Your Ref: OWQC20308
Our Ref: EP/135/18/PL
Please ask for:
Stuart Corbey

Variation of condition imposed under EP/139/16/HH relating to approved front elevation plans.

17 Seaview Avenue East Preston

DRAWN BY AP	CHECKED BY AP	DATE 15/01/16
SCALE (@ A1) 1 : 100	PROJECT NUMBER APA/024/CLOSE	REV
DRAWING NUMBER A104 Rev H

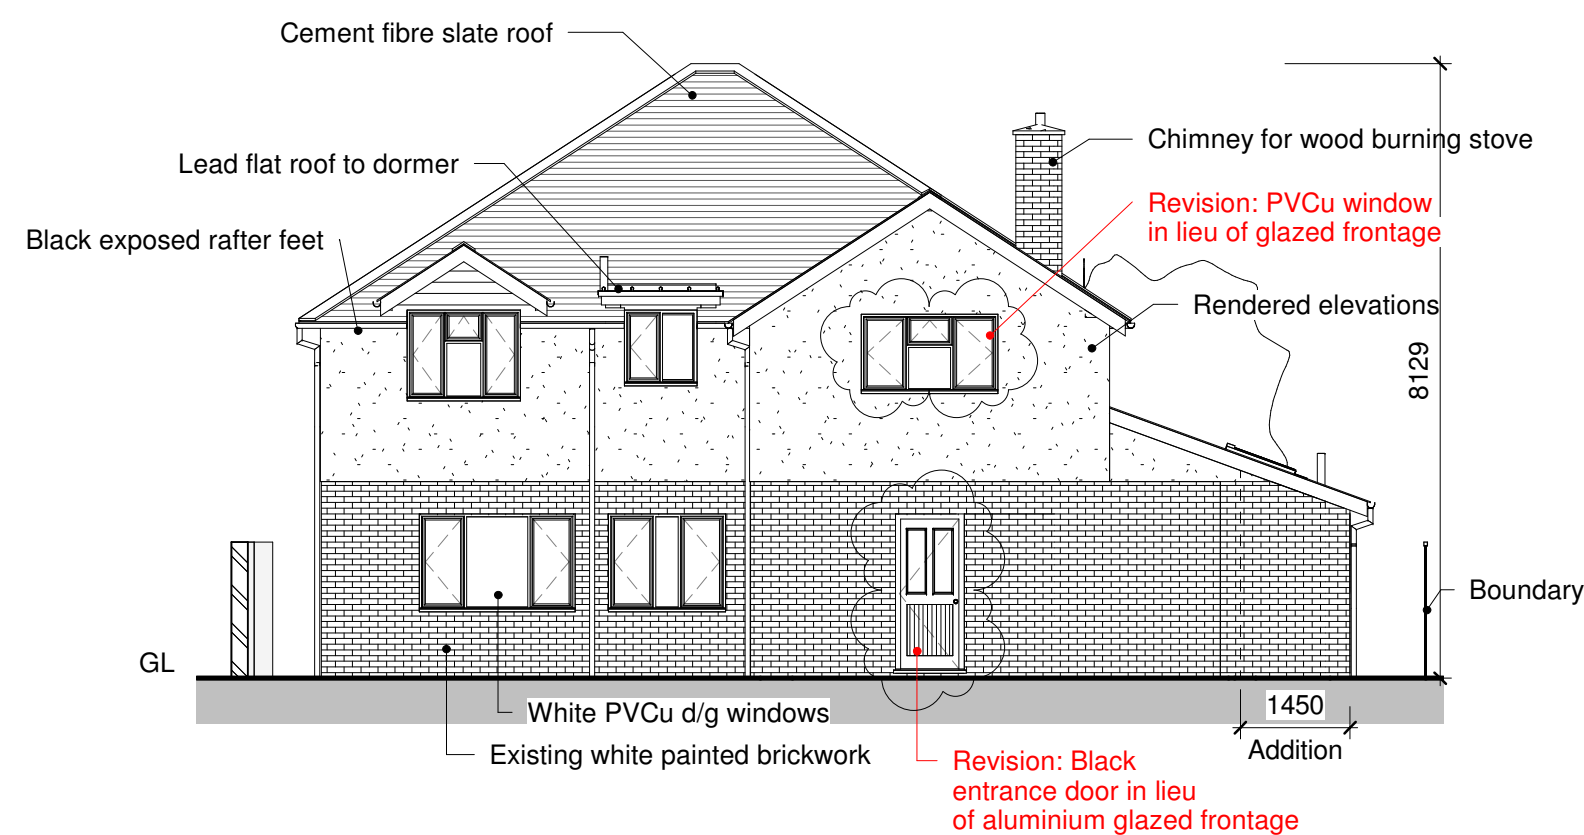
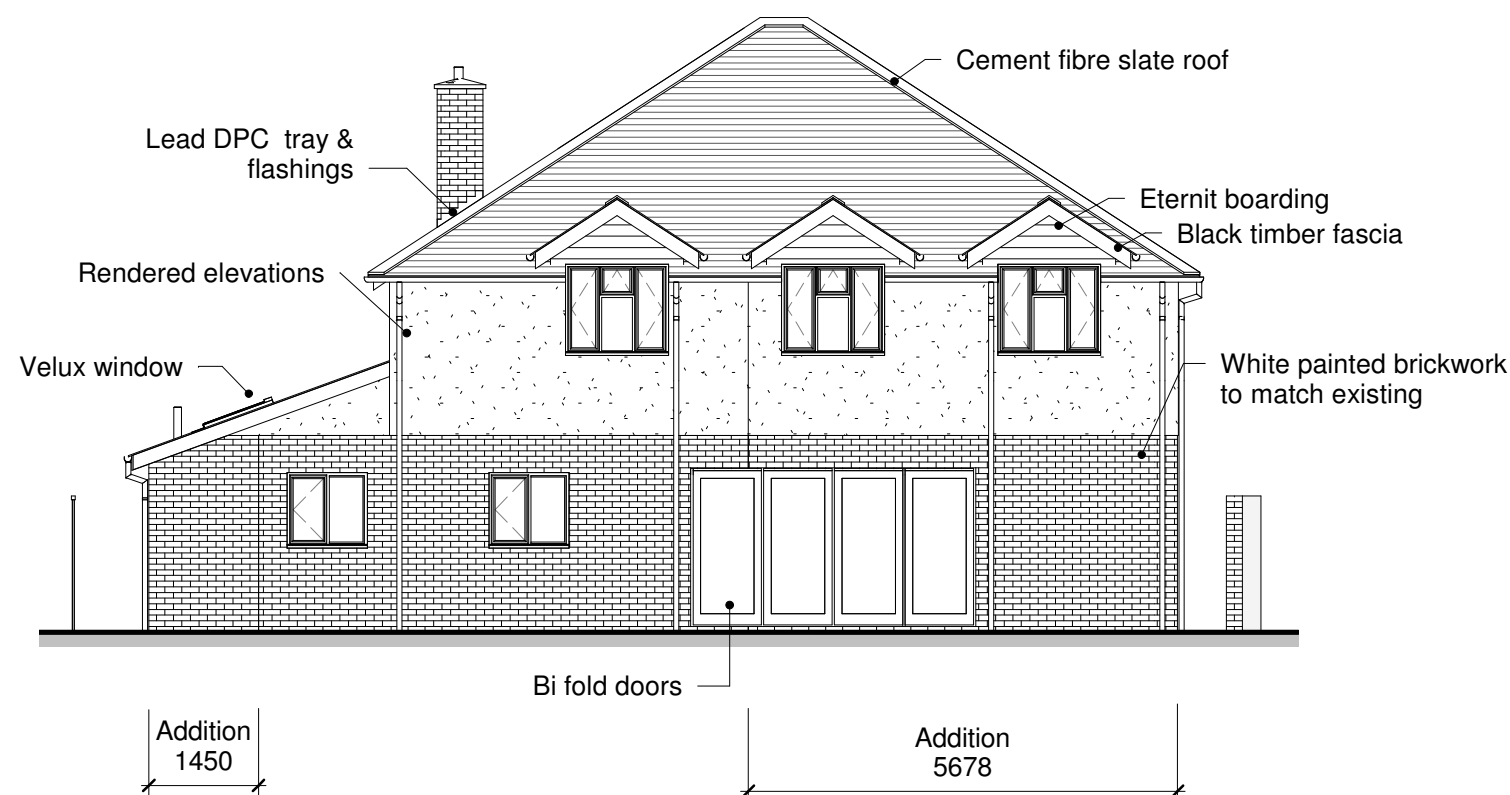
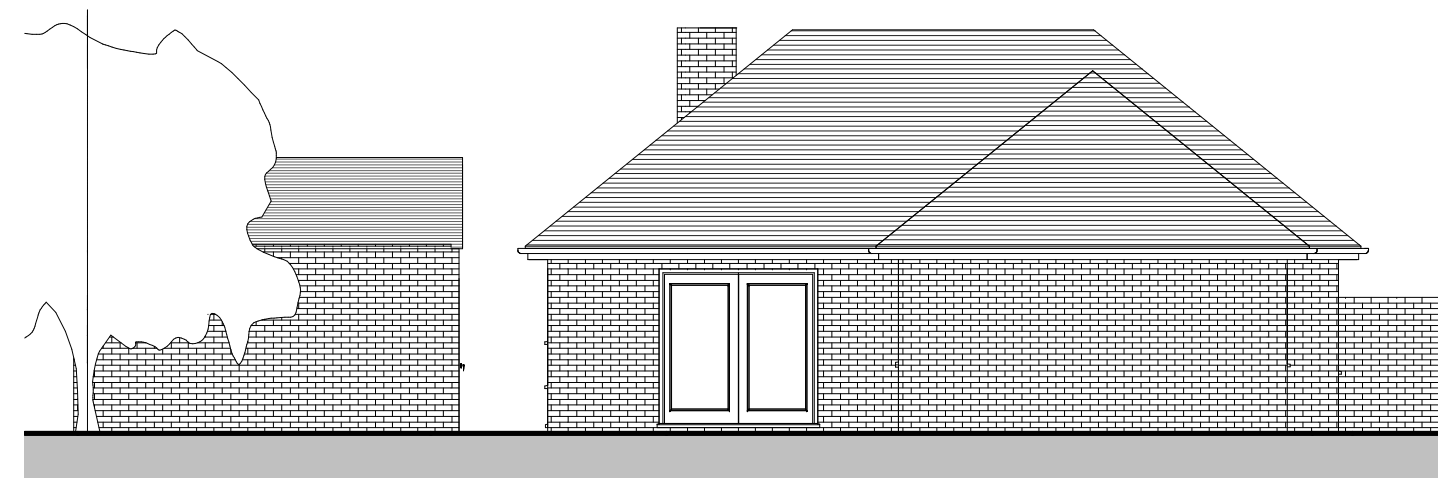
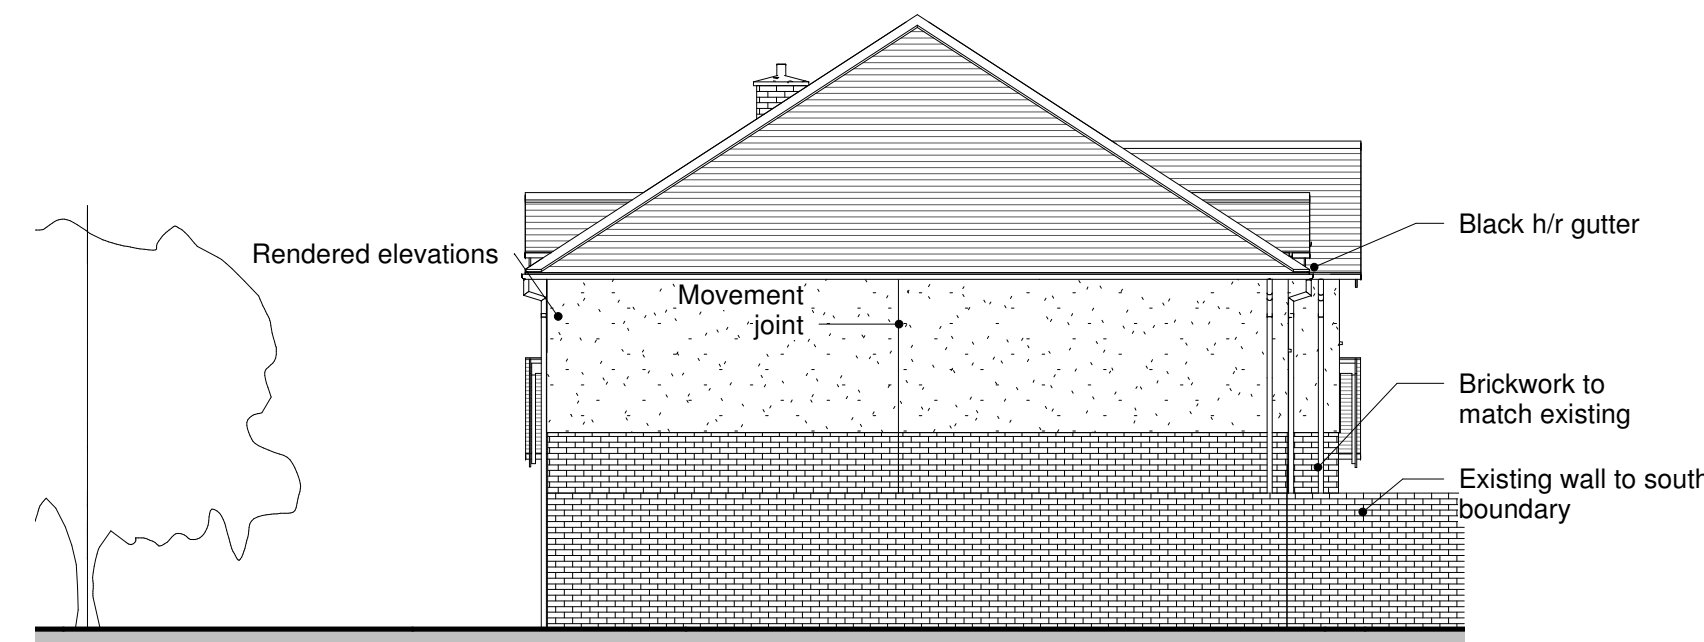
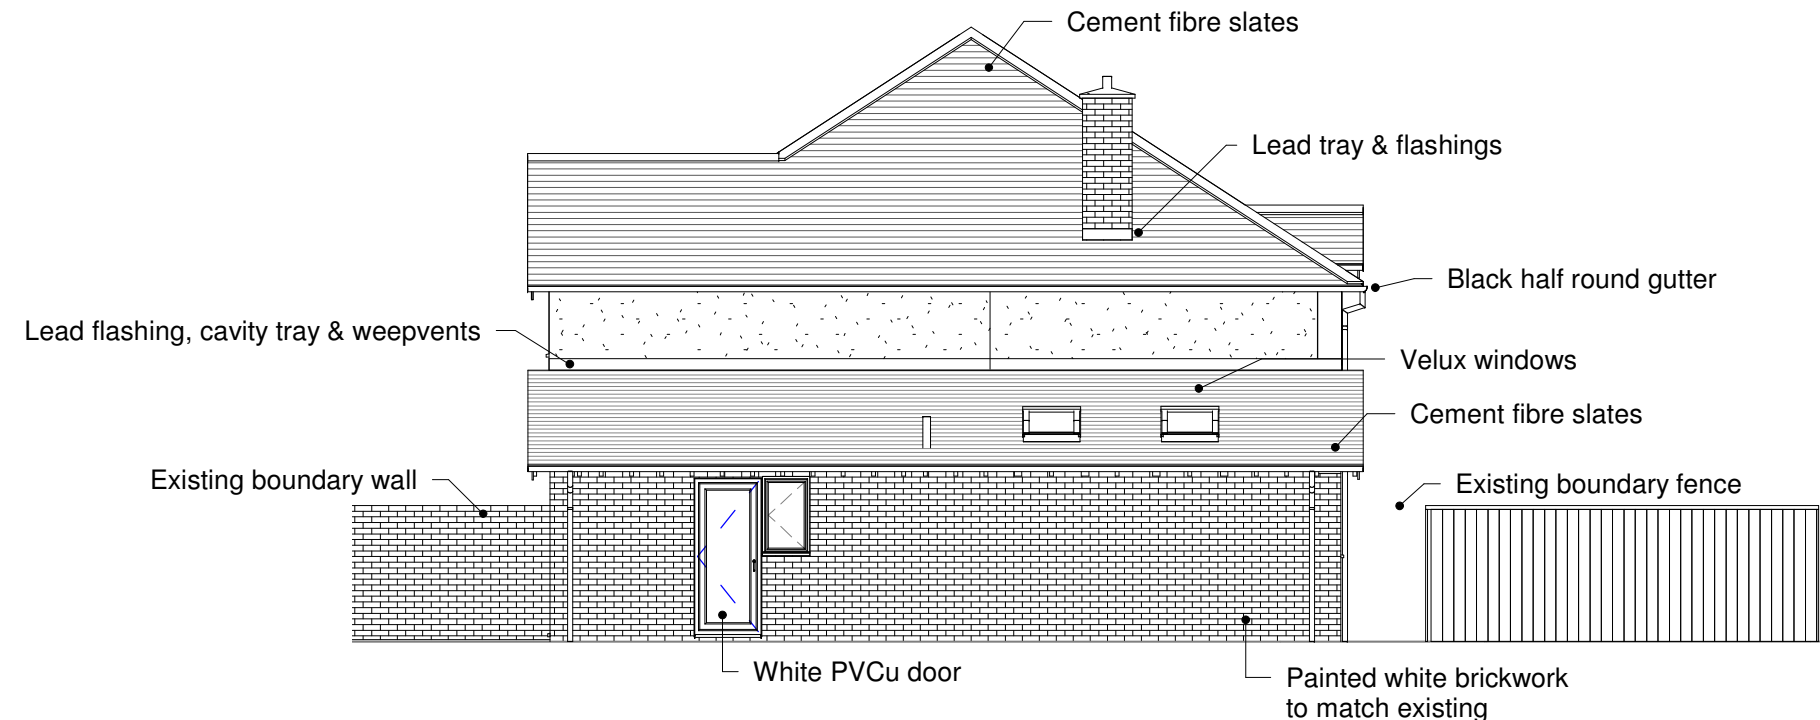
However, it is concerned there is no detail of the roof colour for the property. It would welcome the opportunity to consider the preferred roof colour to ensure it is in keeping with nearby properties.
